Application for a non-material amendment following a grant of planning permission.

Number	
Suffix	
Property name	Merrydown
Address line 1	Kingston Lane
Address line 2	
Address line 3	
Town/city	East Preston
Postcode	BN16 1RP
Description of site location must be completed if postcode is not known:	
Easting (x)	507751
Northing (y)	102607
Description

Increase the height of the proposed structure by 300mm over that approved and increase the depth of the structure by 500mm, retaining distance from high and neighbours boundary as per the original proposal.
Replace barn style doors with Roller garage door to enhance security and accommodate traditional oak knee bracing.

DATE May 21	SCALE Shown on A1	DRAWN BY RF
JOB NO. 21043	DRAWING NO. 2.01	CHECKED BY MF
		REVISION

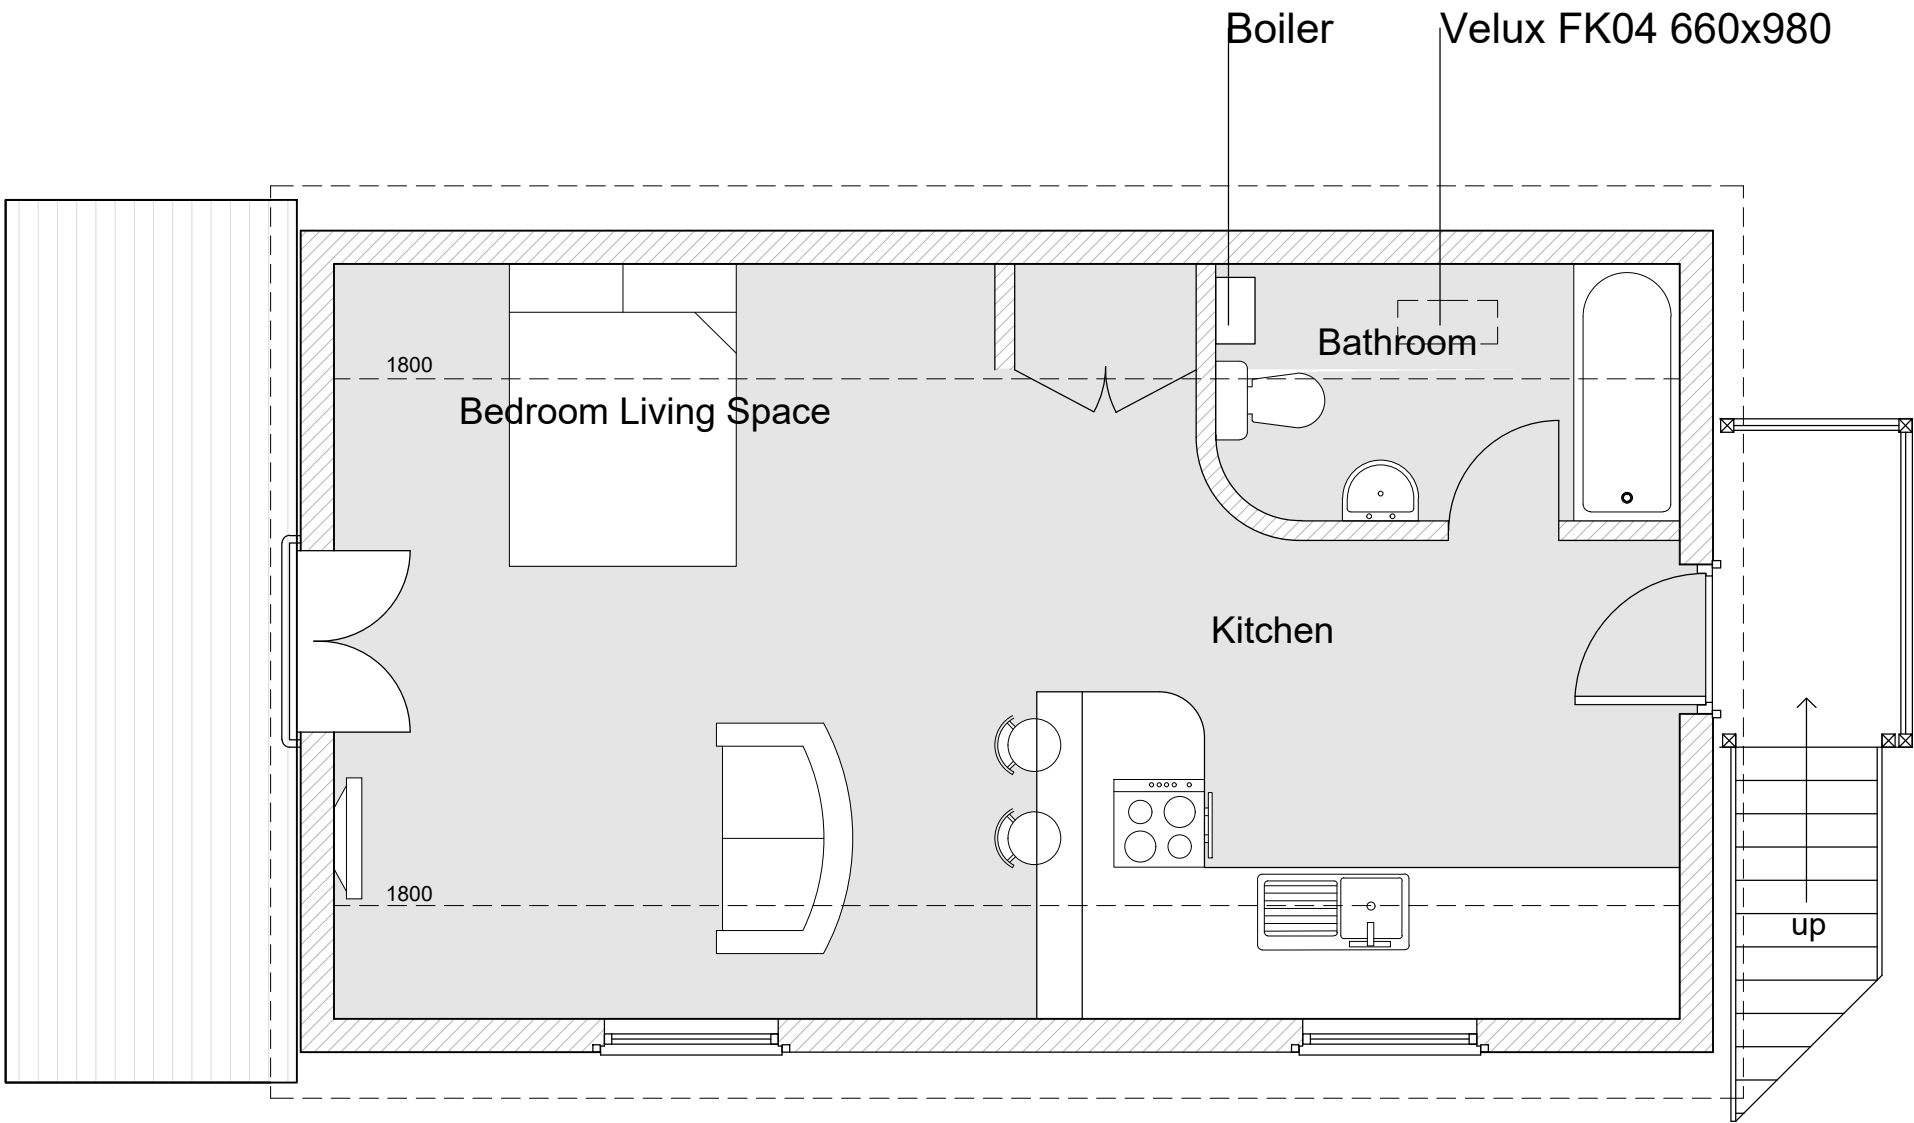
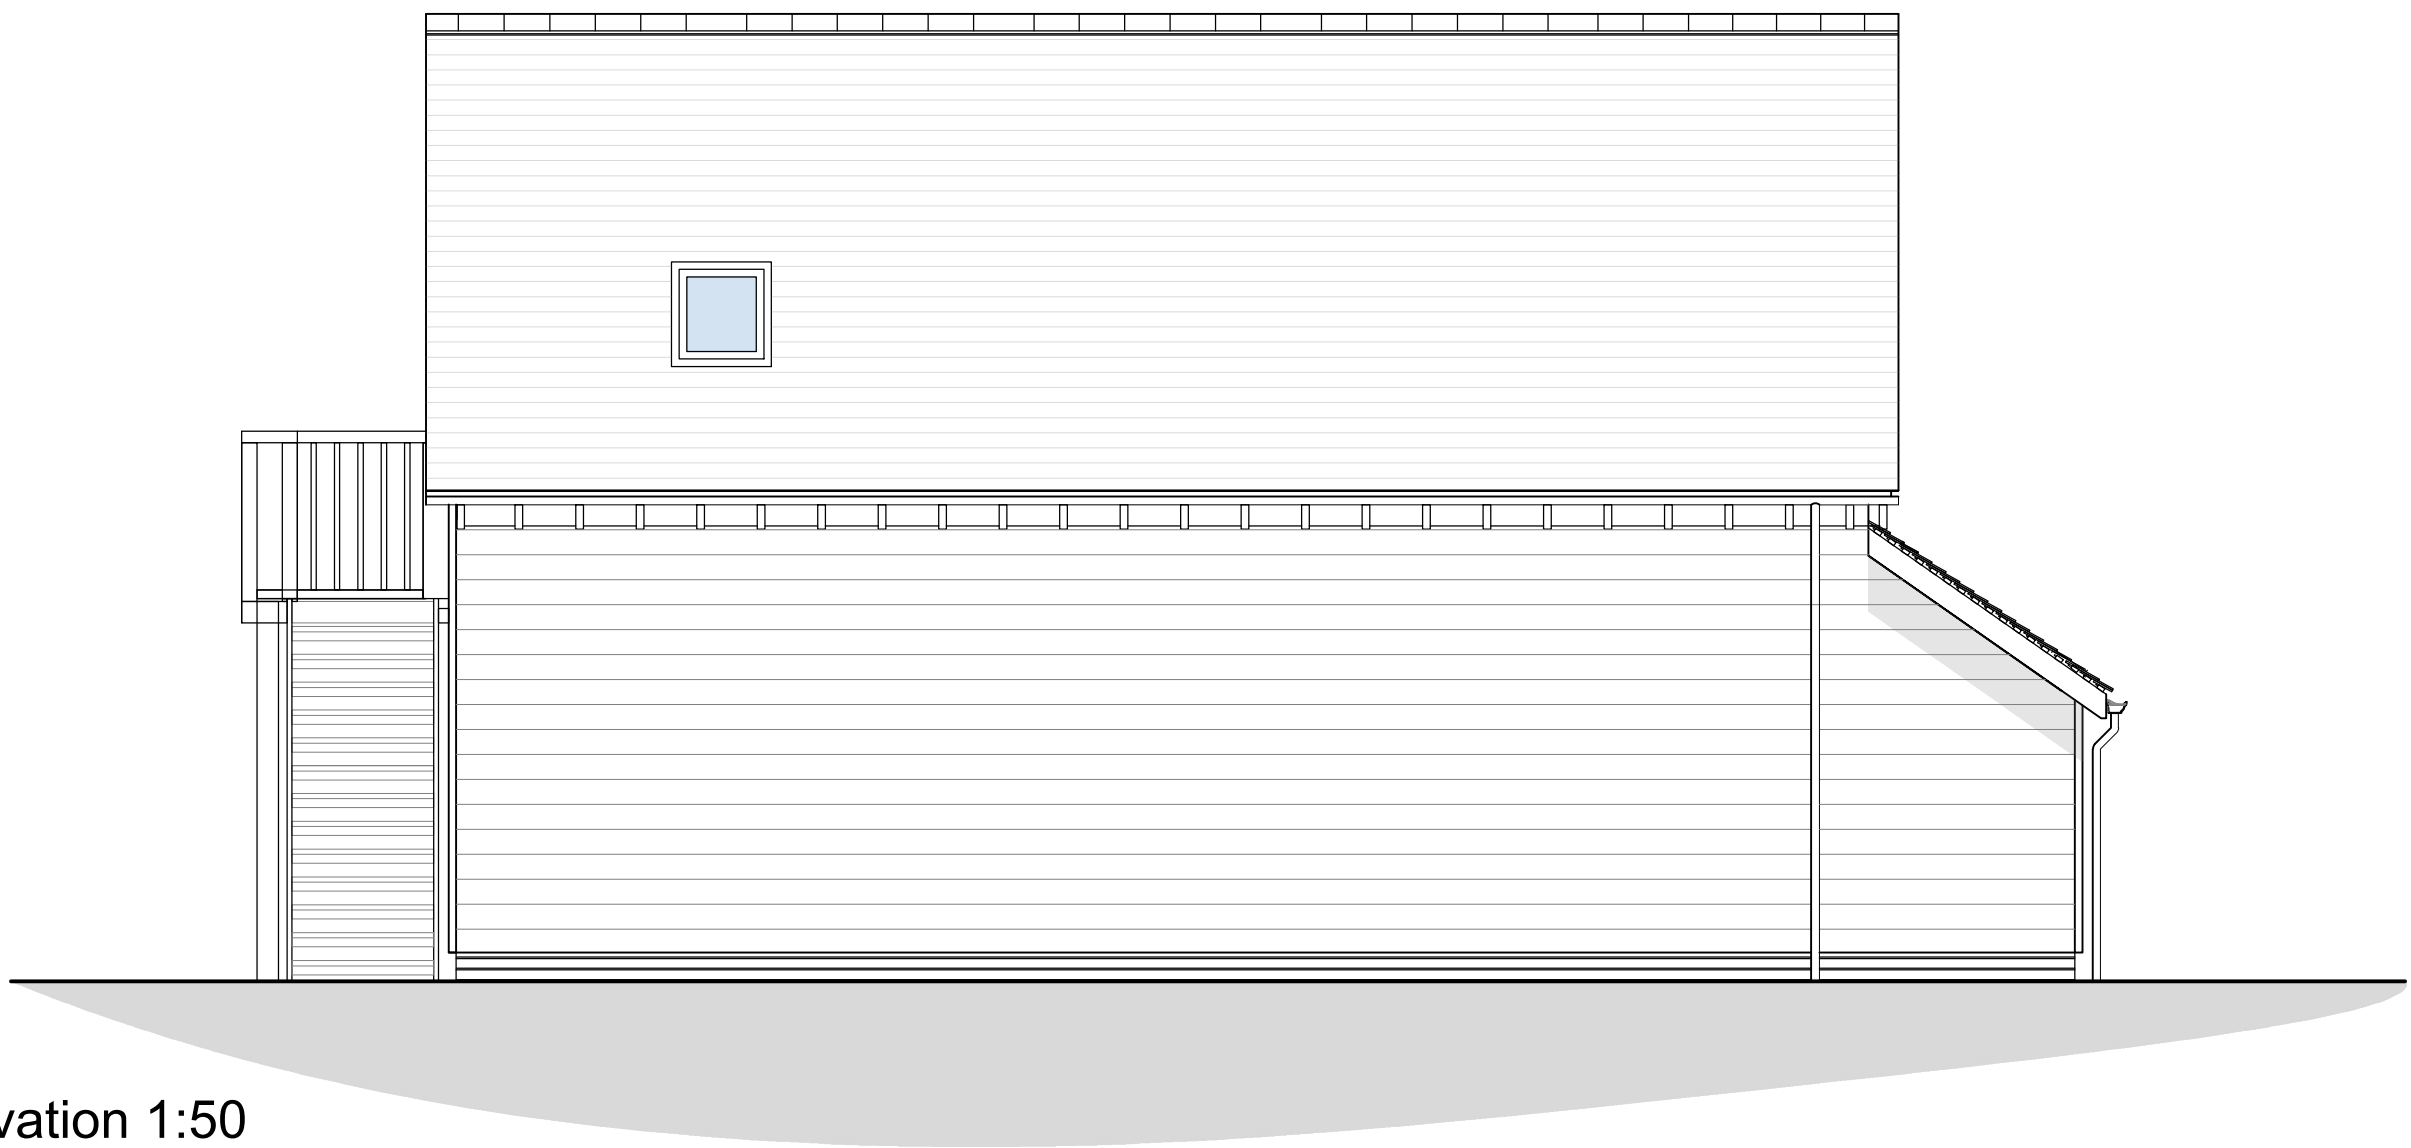
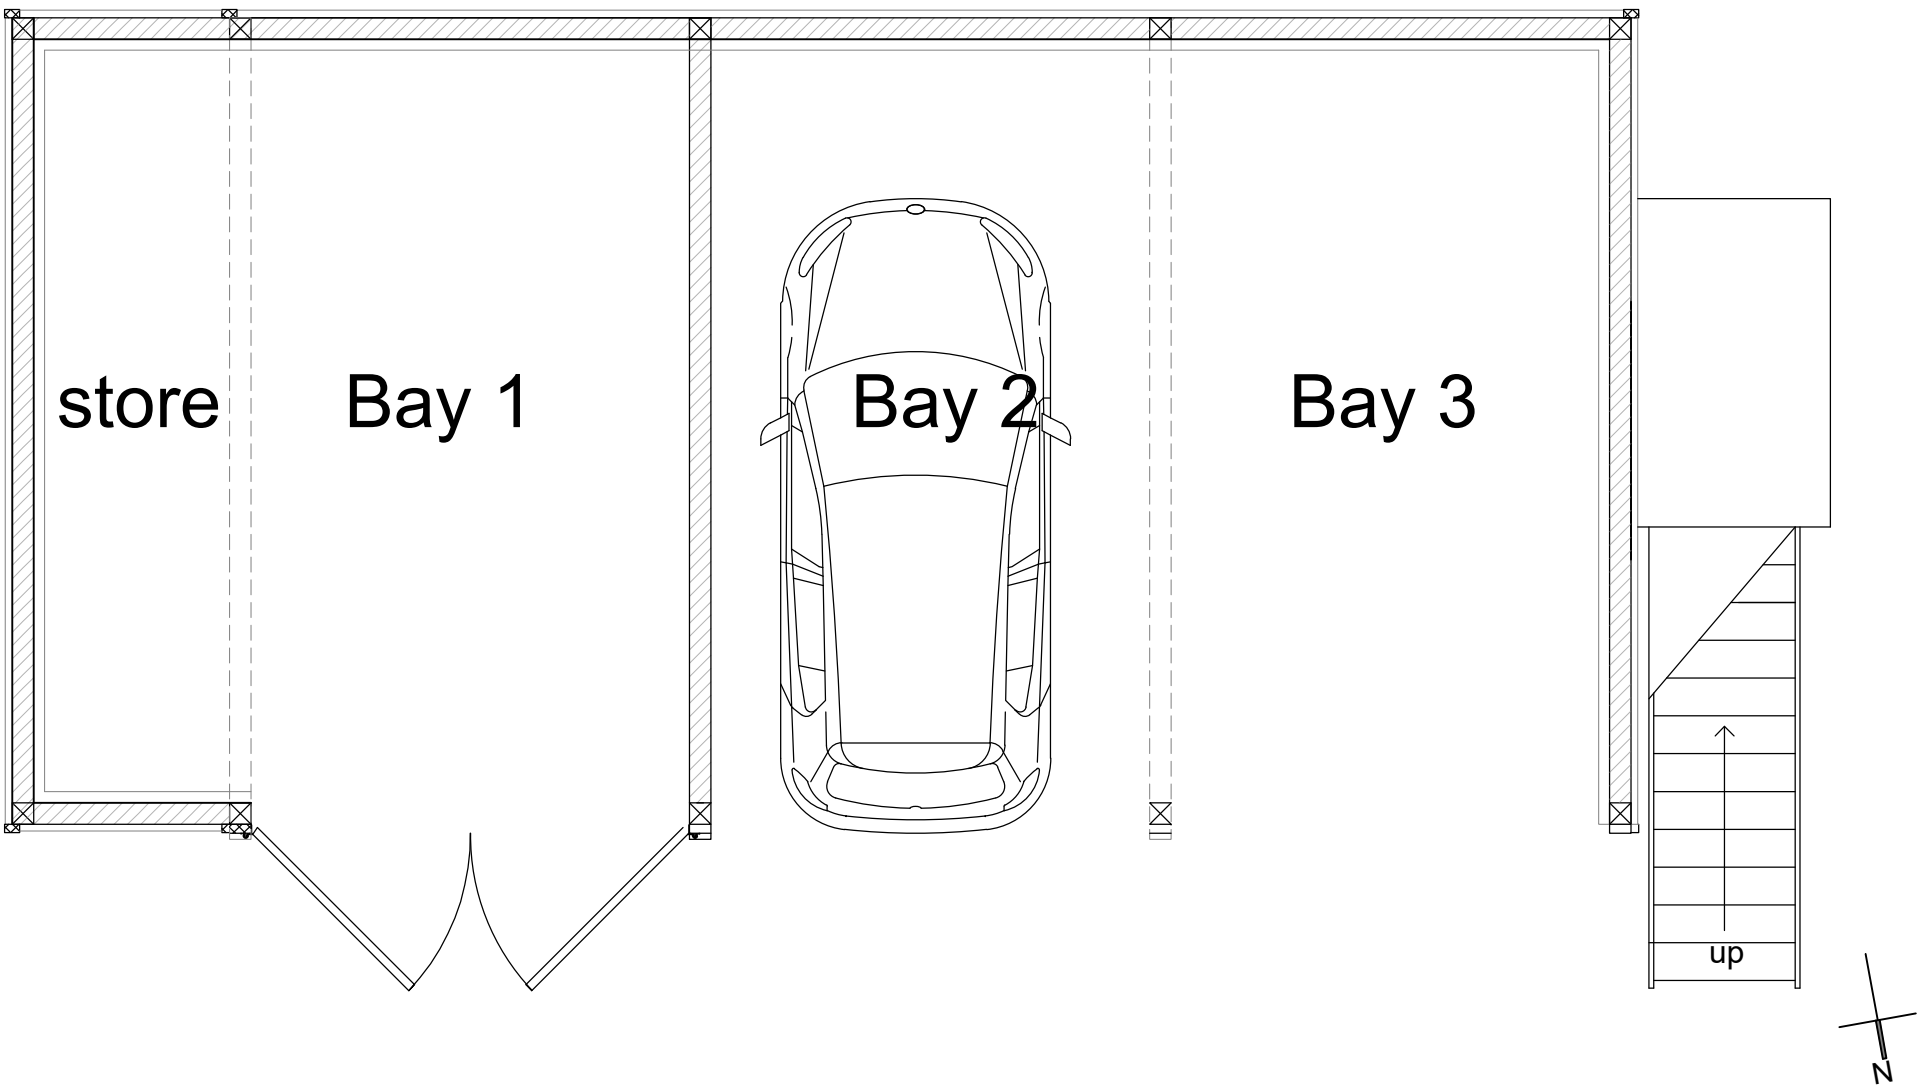
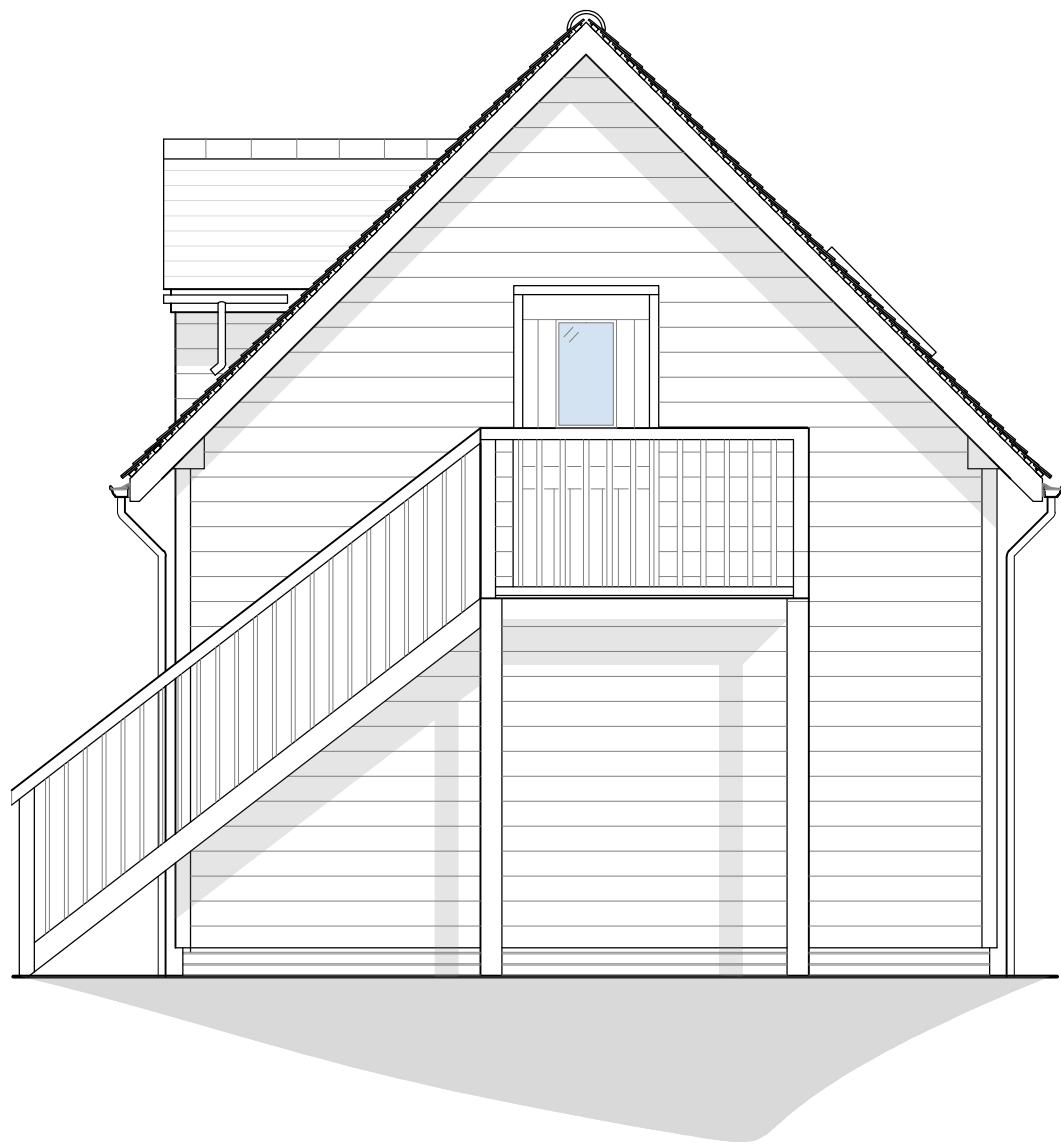
To accommodate a revised roof structure, which will more more cost effective, and to improve the garage depth taking into account an internal framed roller garage door (which will improve security).
